Grandview Metro District Project 1041 Submission

August 6th, 2021

Updated January 7th, 2022

Engineering Review

**WATER MAIN IMPROVEMENTS**

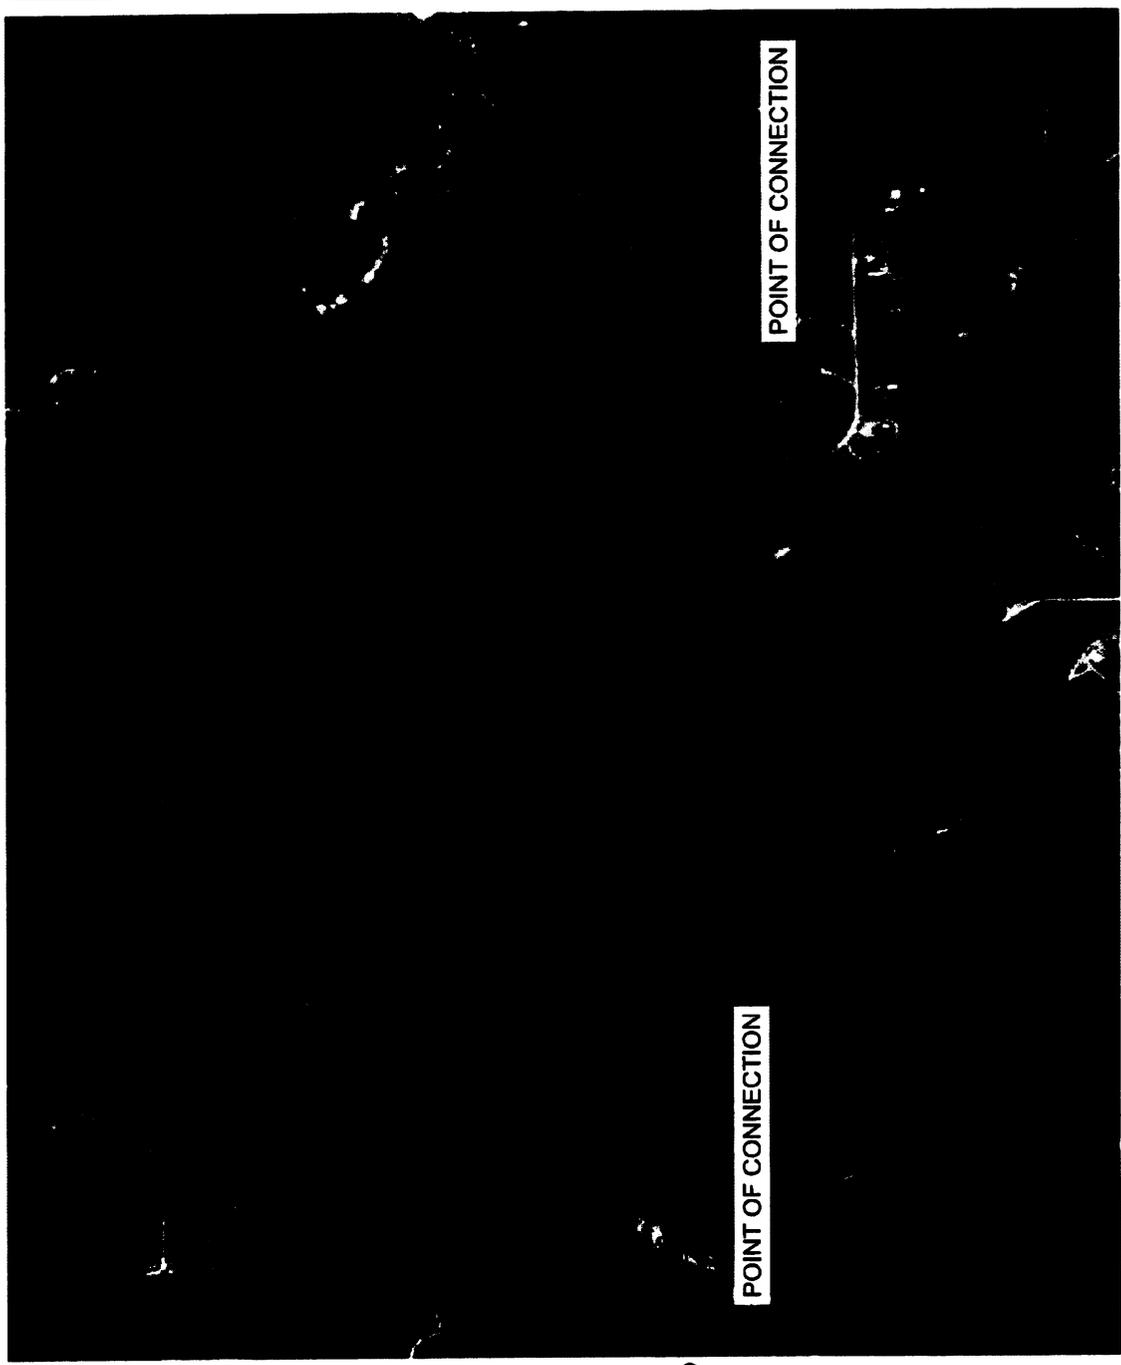
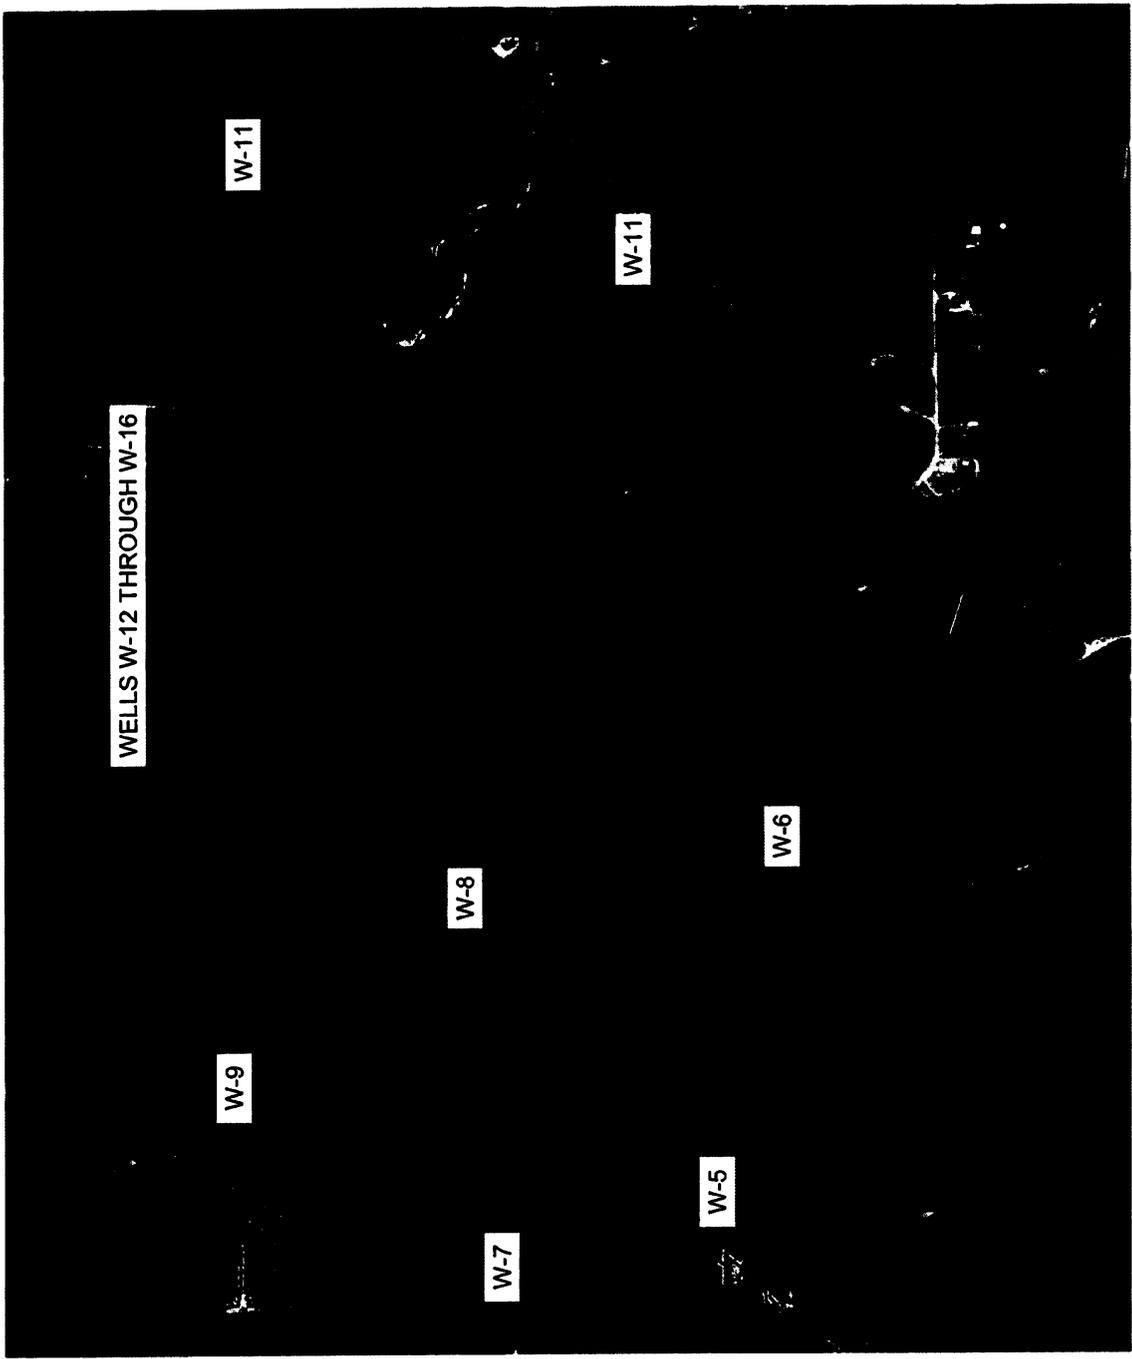
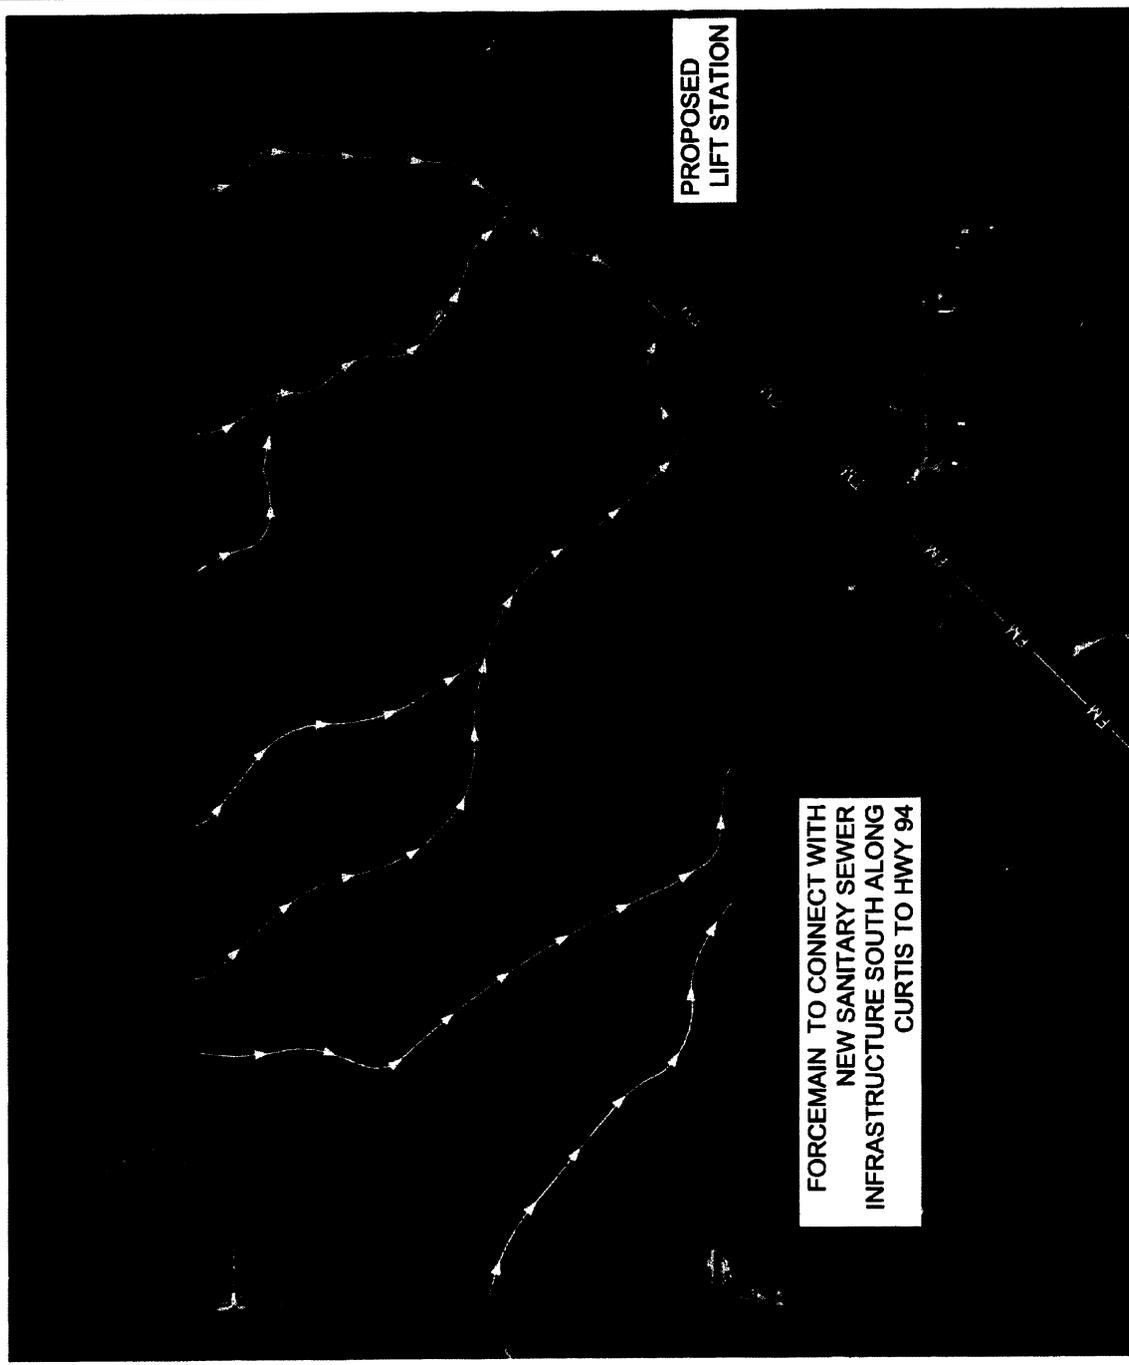
Repeat Comment:
here you shall
reference table of
contents and
provide A general
map of all well
sites, lines w/ size
label, forcemains,
tanks sites, pump
station, treatment
facilities, well
houses, etc....
shall be provided
(general map with
road names,
legend and a large
scale) This is a
one stop map that
depicts every thing
included in
systems that is
being approved)
Make sure to label
sizes ie: 2m gallon
tanks, 36" water
line, etc

show on maps

show tank locations as well as pump houses etc on maps

All of this infrastructure shall be mapped on the water and Sewer maps (include alternatives so we dont need to amend the 1041 later)

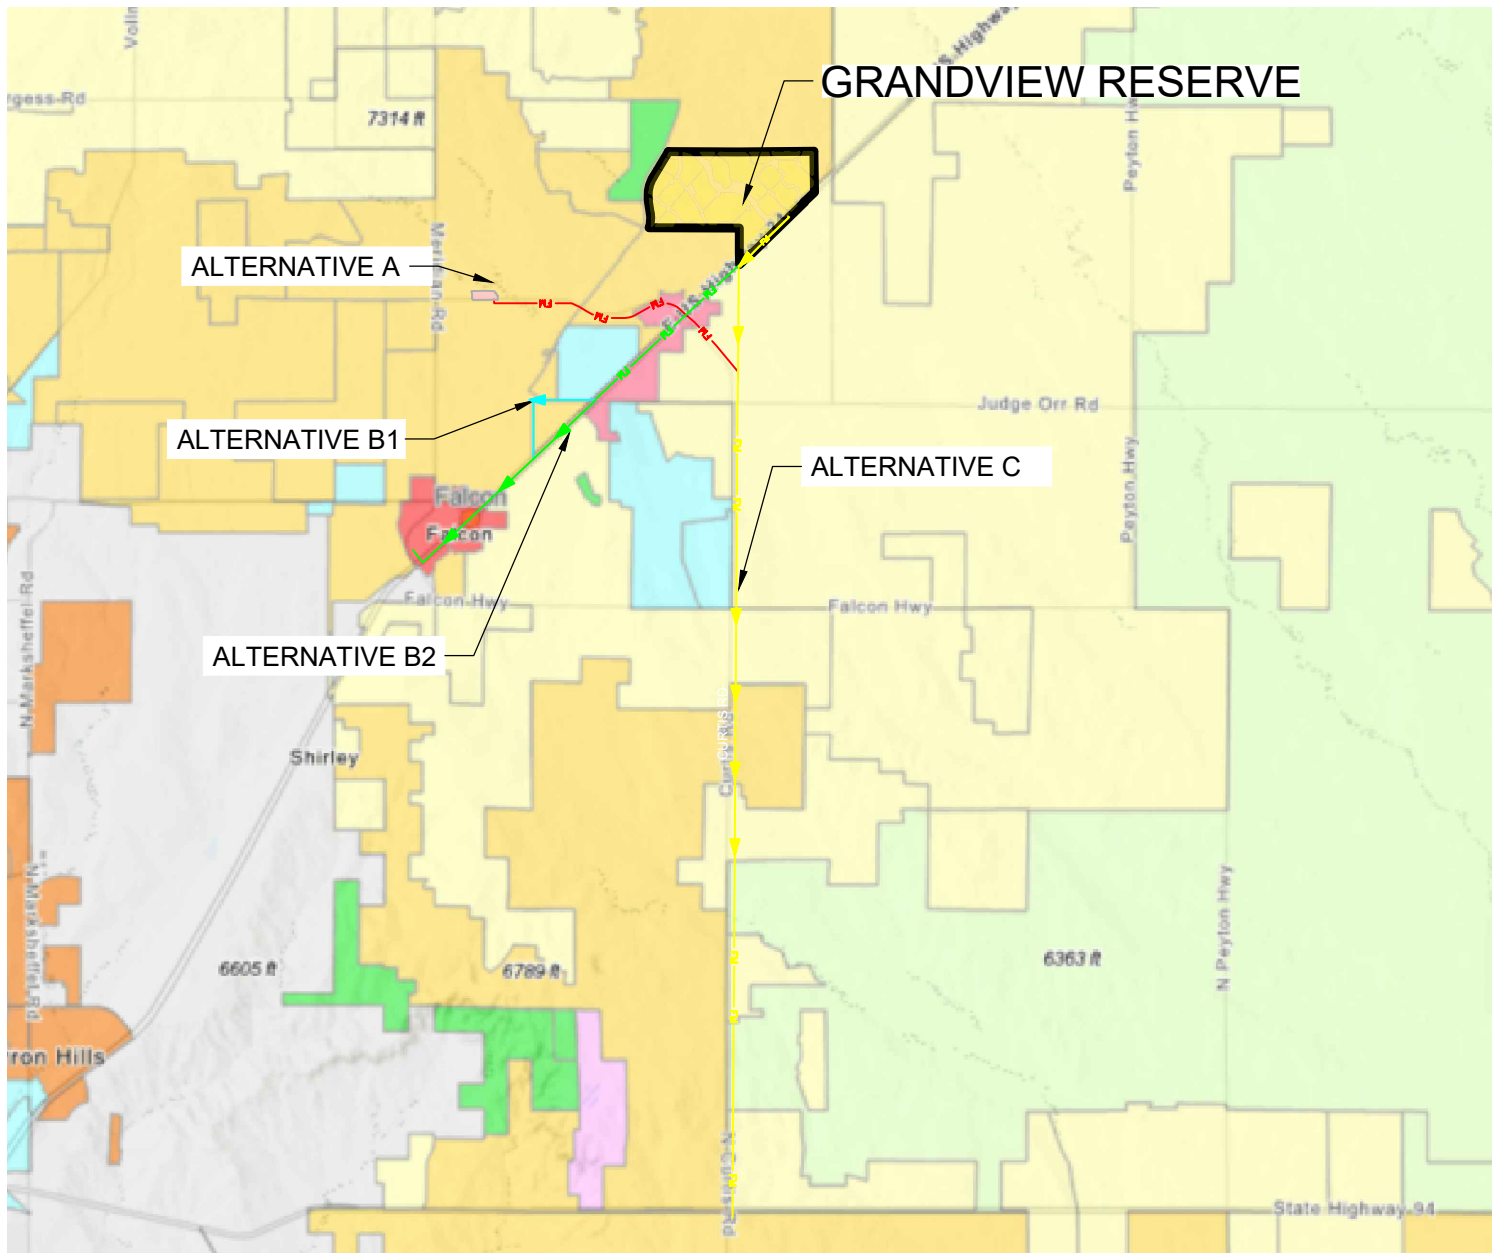
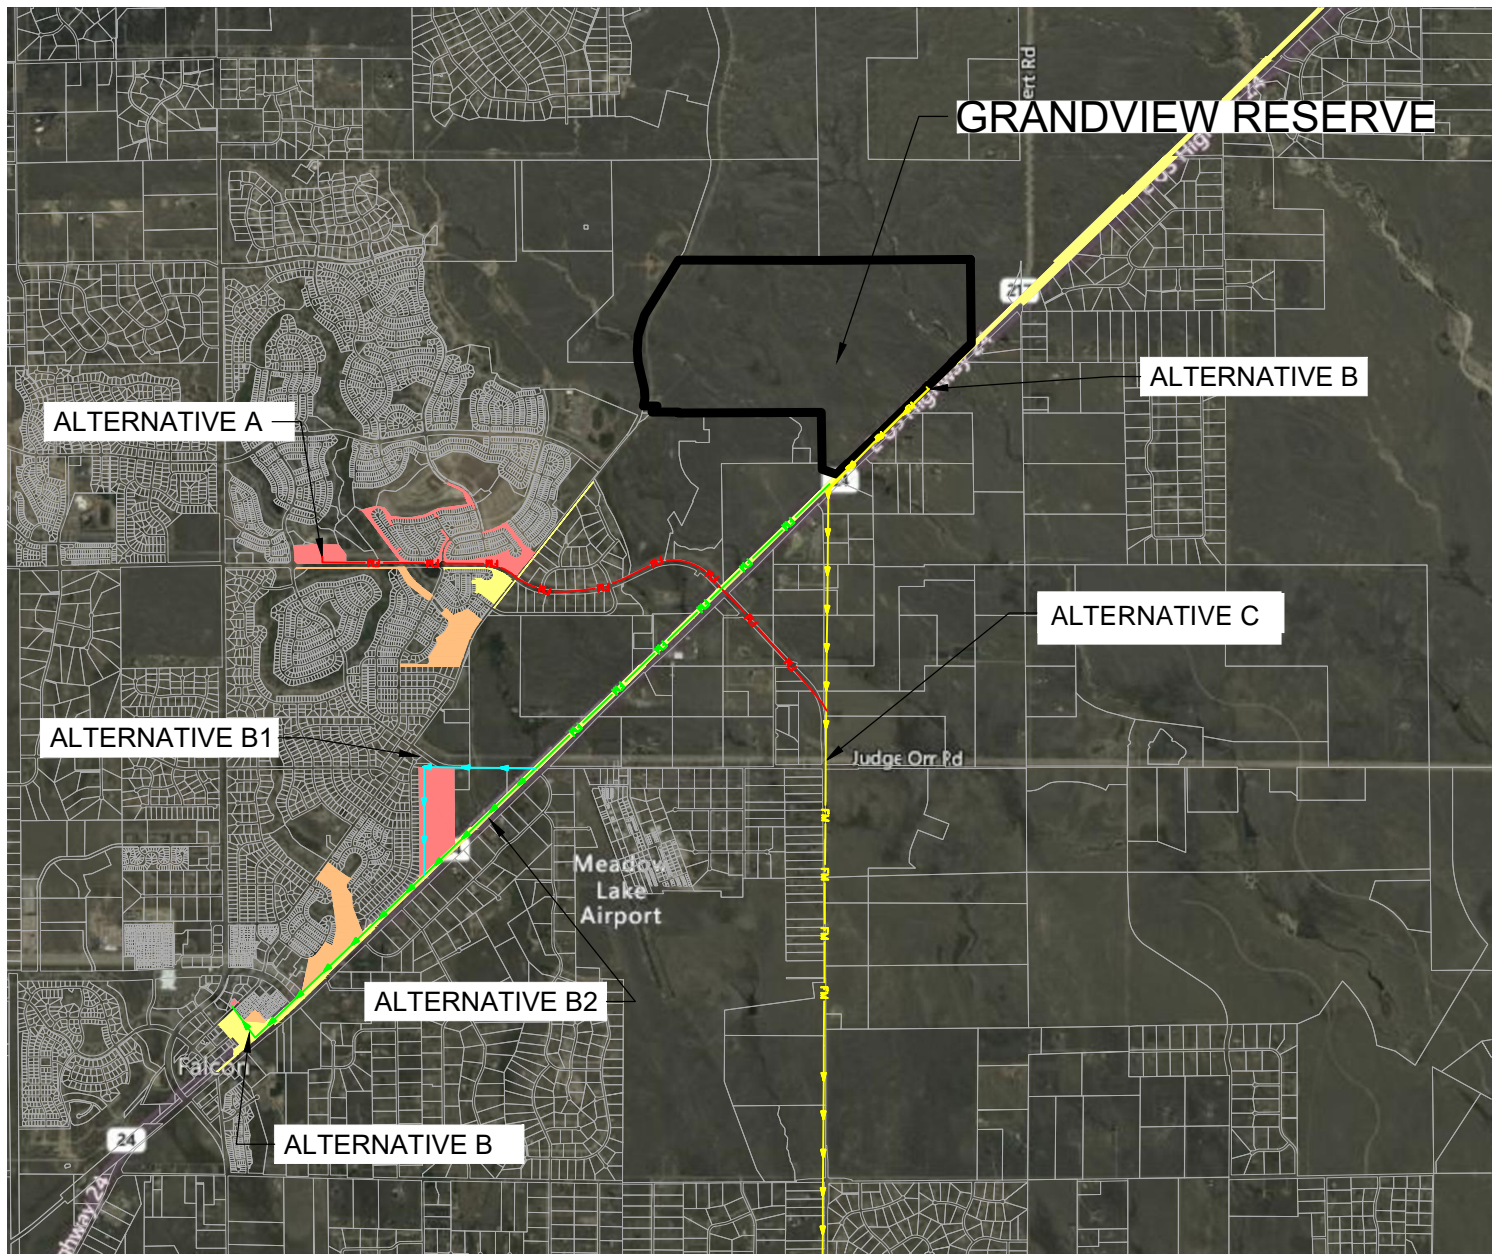
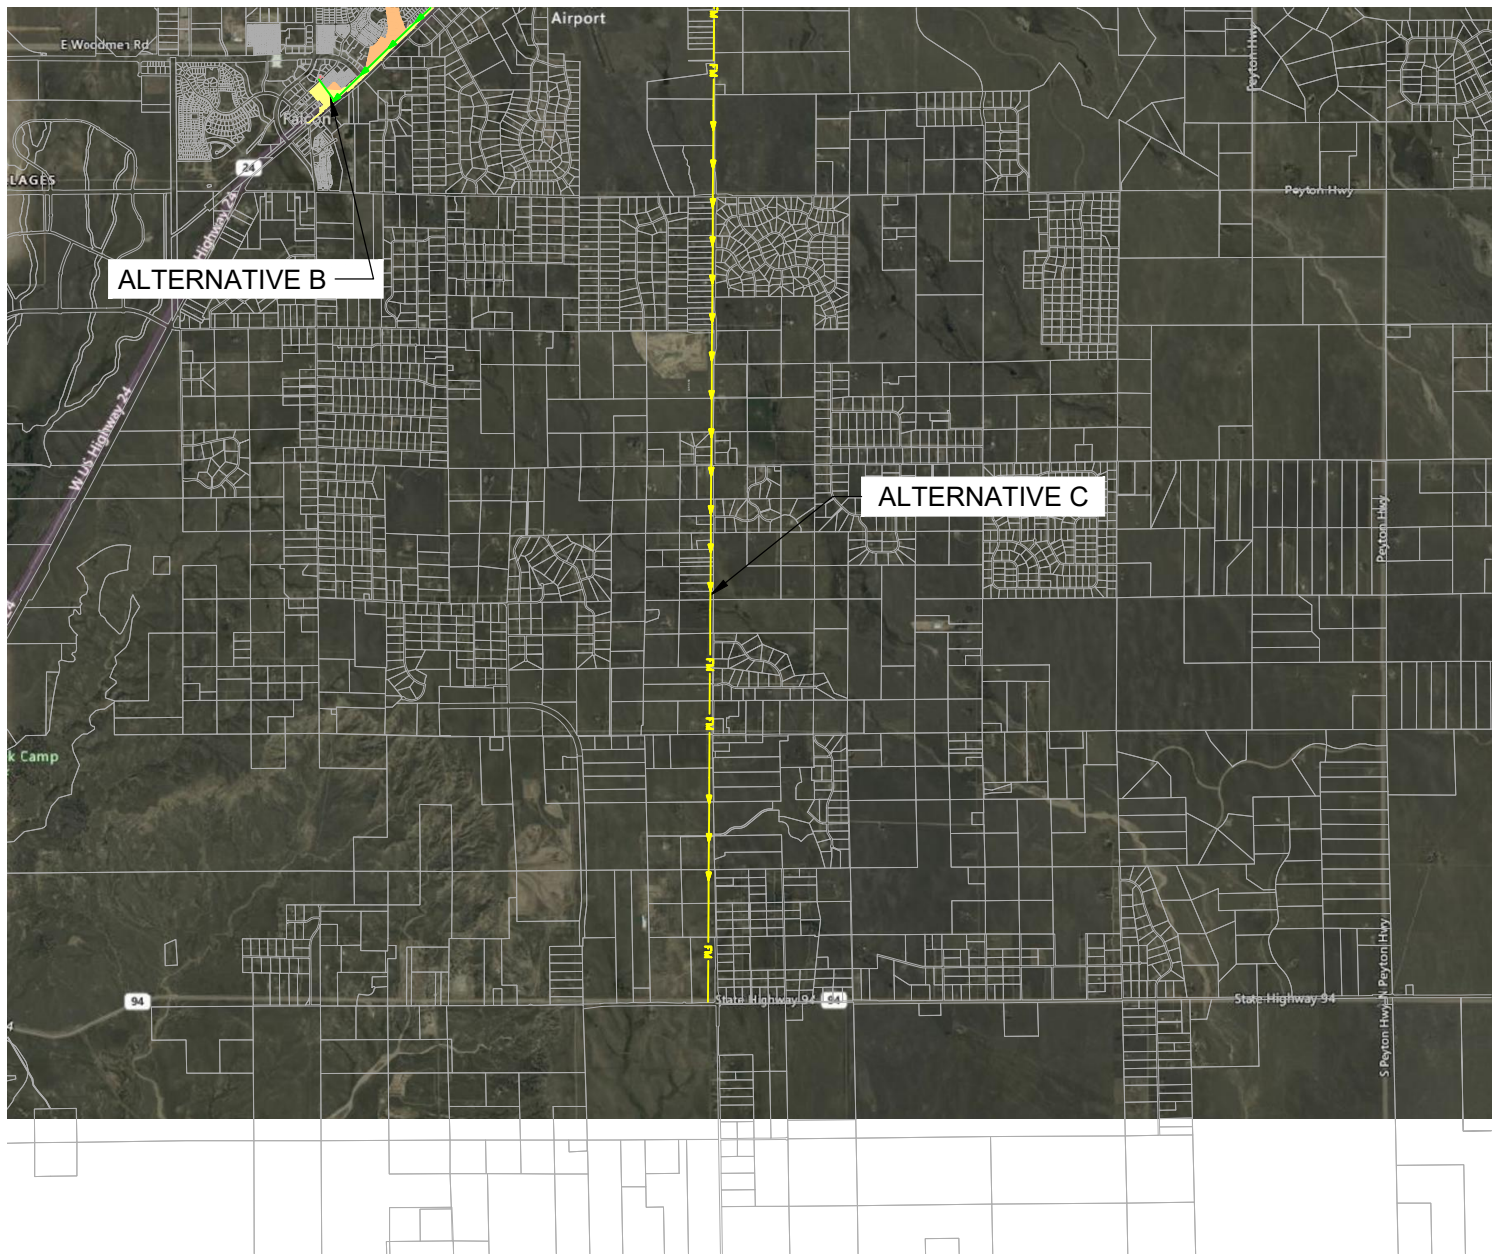
Please depict the expansion Cherokee MD will have to do to serve this development so that Cherokee MD does not have to do a separate 1041 which will delay your development because to build out

Grand-view; Cherokee has to expand a treatment facility and possibly add a lift station. Show this on the map, and include in text. This 1041 is for the siting of the whole sketch plan area not just the first PUD. IF YOU do NOT, when you go to second phase you may be delayed until CMD obtains the approvals for their expansion which is necessary to handler the wastewater flows from Grandview. Use options on maps if you do not have details.
